The Secretary
Department of Planning and Environment
GPO Box 39
Sydney NSW 2001

25 May 2015

**Re: State Significant Development SSD 6594
Blayney Export Meats Smallstock Abattoir – Newbridge Road, Blayney**

Figure 10: Concept Landscape Plan

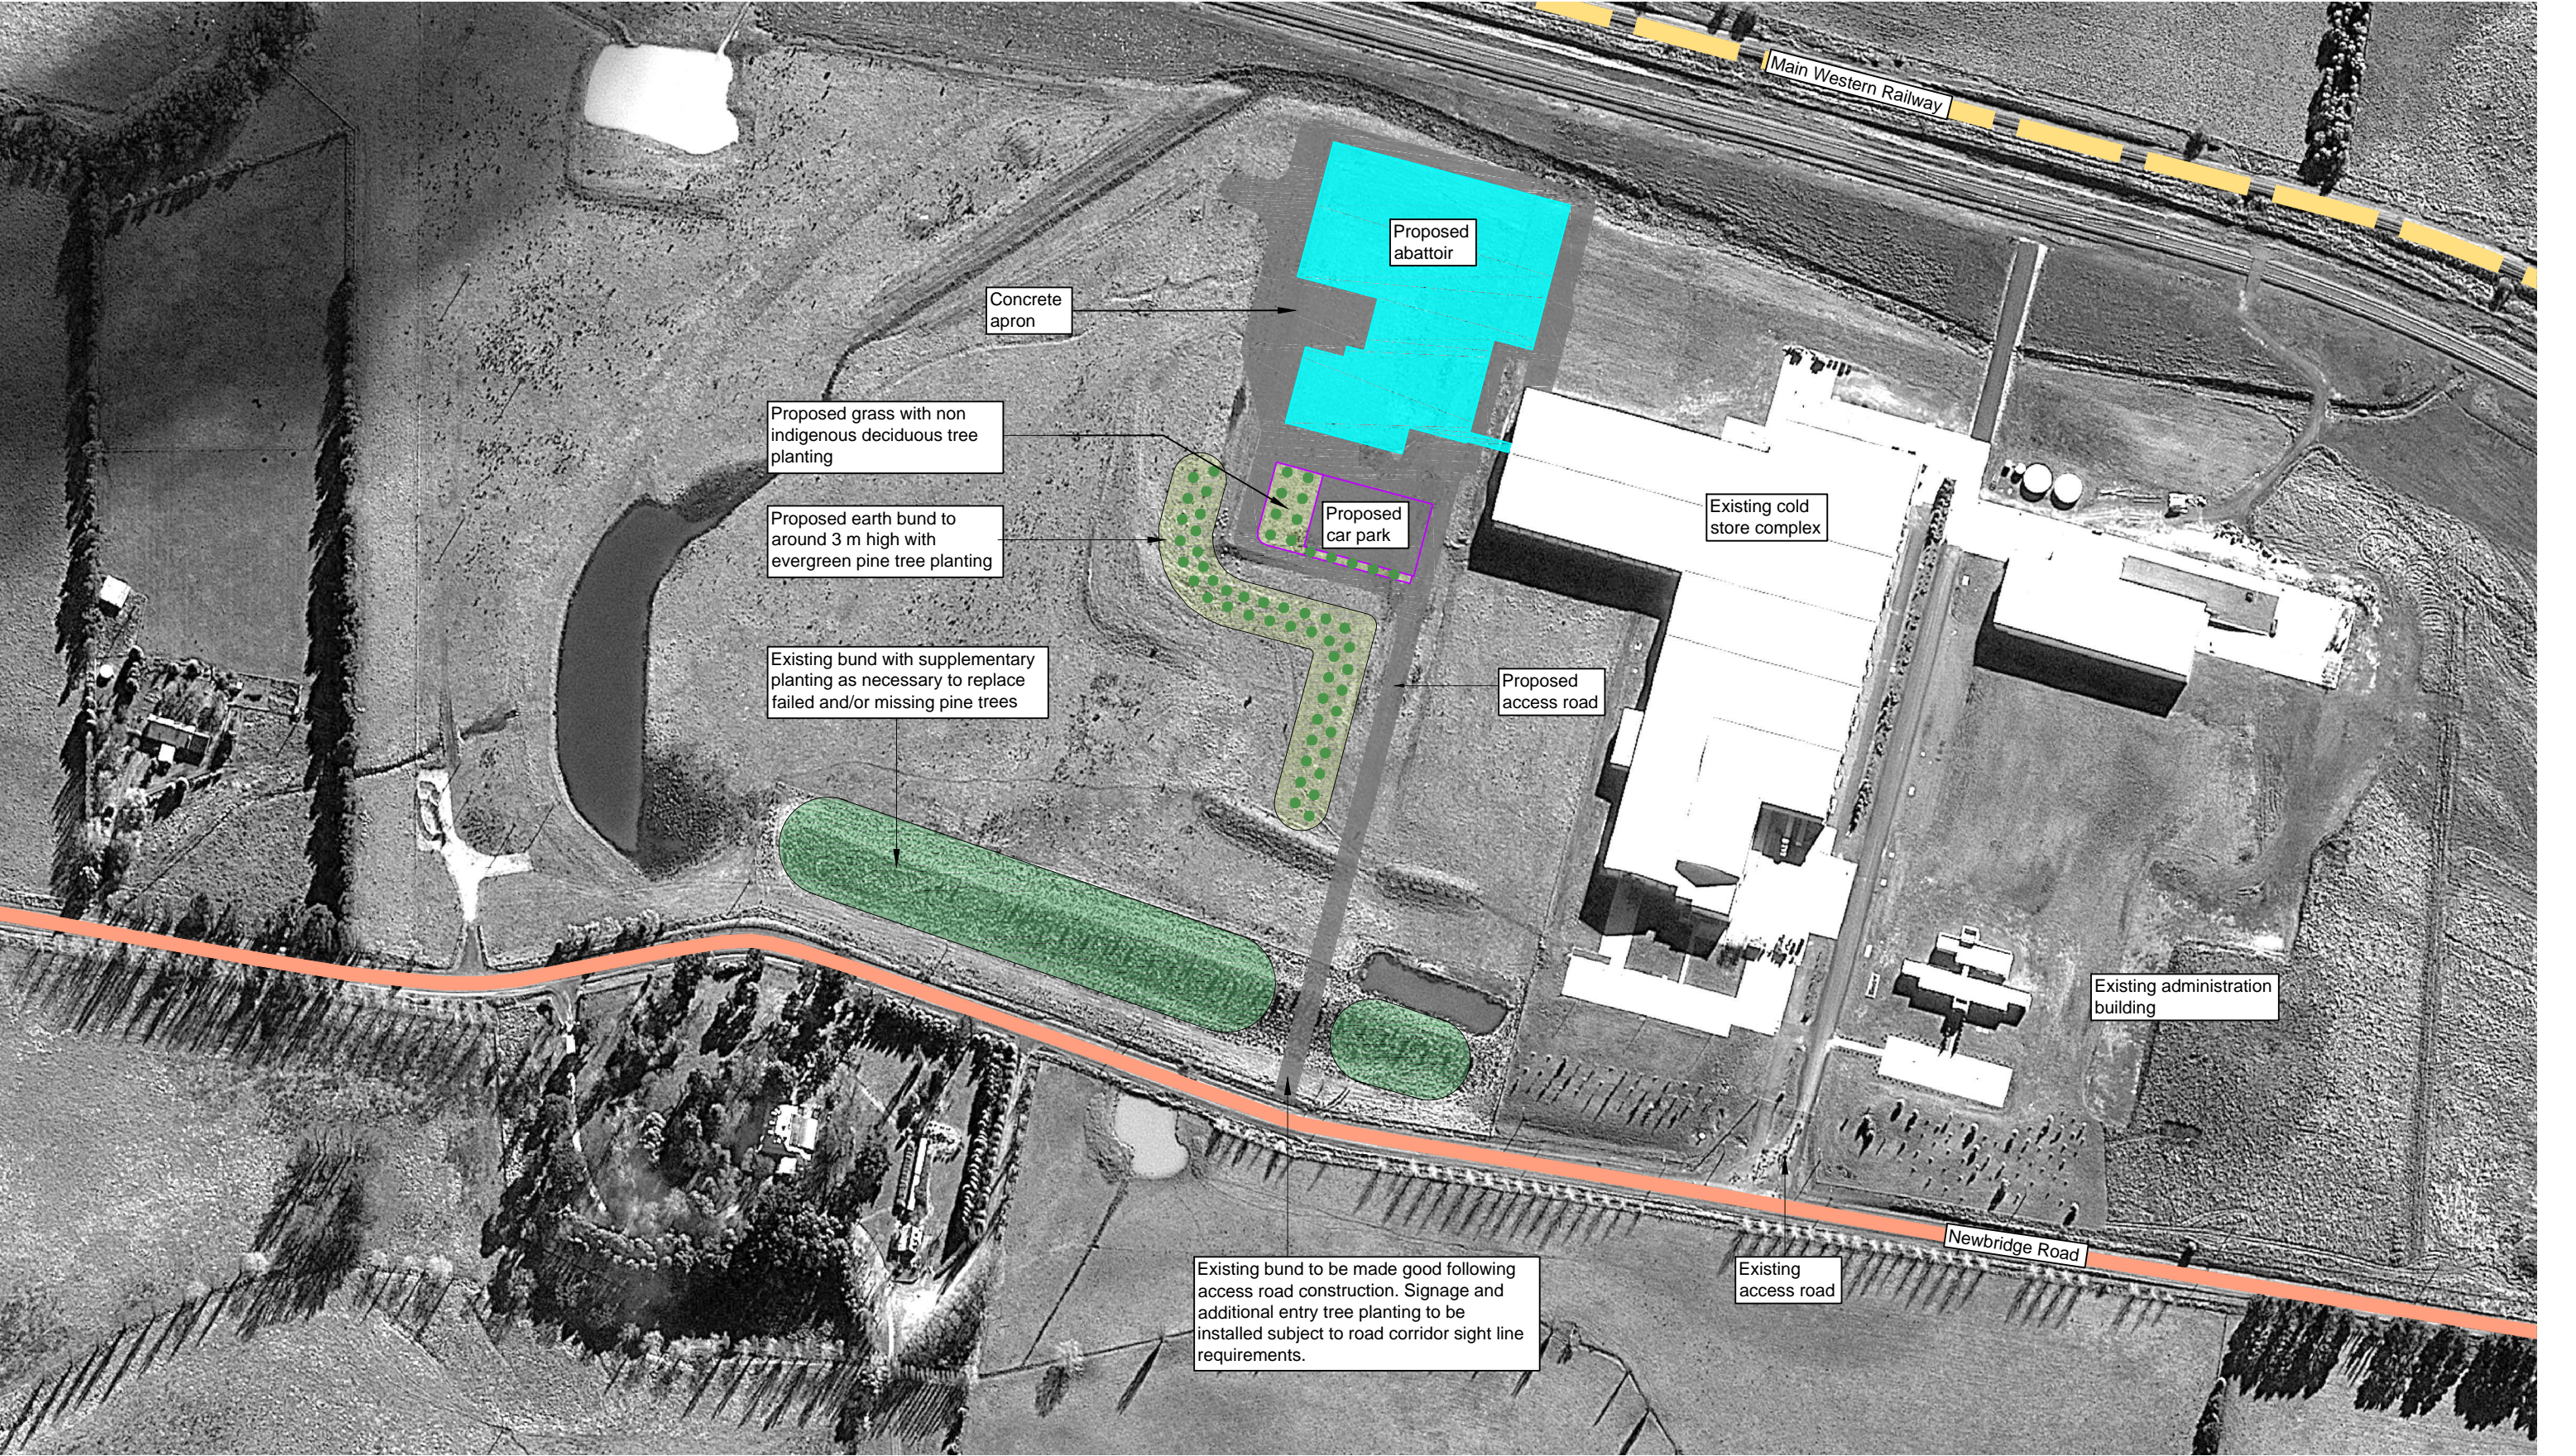
There are no details of the extent of earthworks, extent of fill or finished ground levels for the proposed visual bund that forms part of the application. There are no dimensioned or scaled drawings showing the length of the visual bund. There is no analysis of the impact of earthworks on water movement across the site.
